**Consultation Response from KC,
Highways Development Management**

2024/90383 Yew Tree Farm, The Village, Farnley Tyas, Huddersfield, HD4 6UQ

Discharge condition 3 (Phase II SI), 4 (remediation), 10 (drainage design), 11 (drainage calculations), 12 (drainage design), 26 (WSI), 33 (highway details) on previous permission 2021/93006 for conversion of existing barn to form 8 dwellings, erection of 9 dwellings, demolition of redundant agricultural buildings and associated works (Listed Building within a Conservation Area)

Date Responded: 15-4-2024.

Drawing Title			
HIGHWAYS AND DRAINAGE			
SECTION 104 PLAN			
Scale	Date	Drawn	Checked
1:250 @ A1	NOV 2023	HM	JB
Drg No.			Rev
4011/112			2

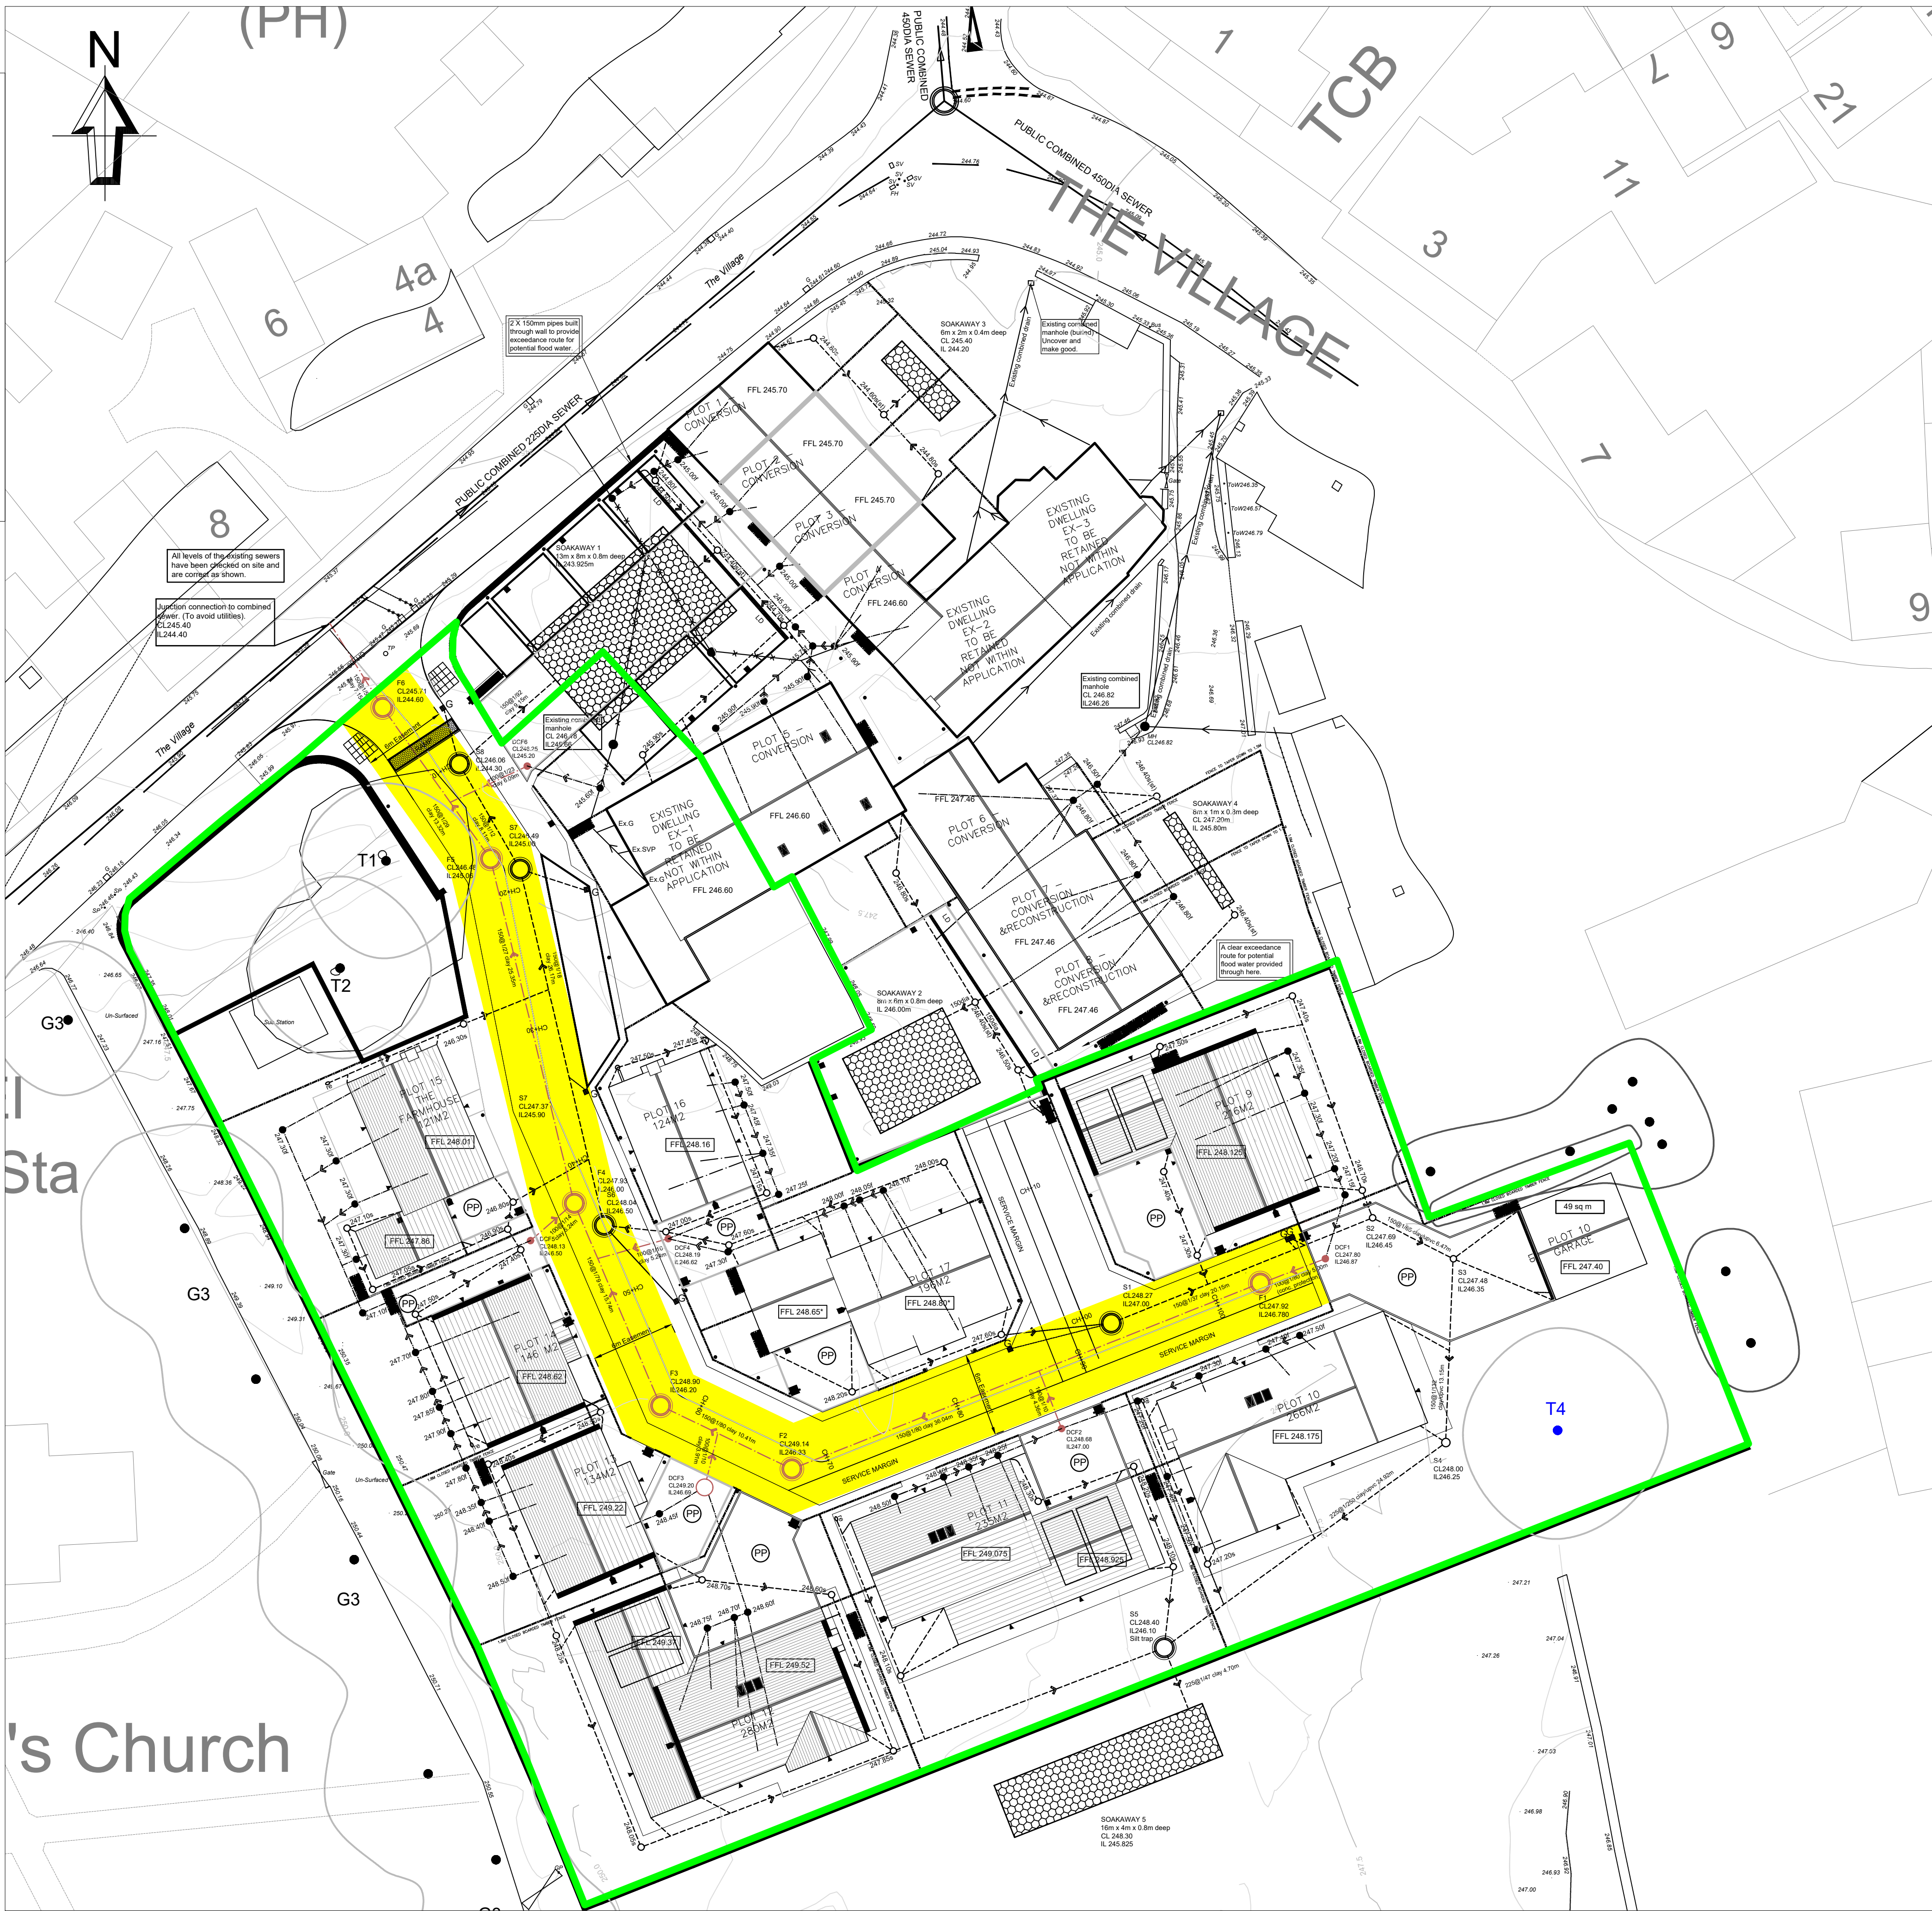
1, The location of road gullies is shown on the Highways and Drainage Section 104 plan (drawing number 4011/112 rev2). It's not clear from the plan what drainage is to be provided at the end of road 2. No longitudinal section is provided to show the gradient of road 2.

This condition should not therefore be discharged.
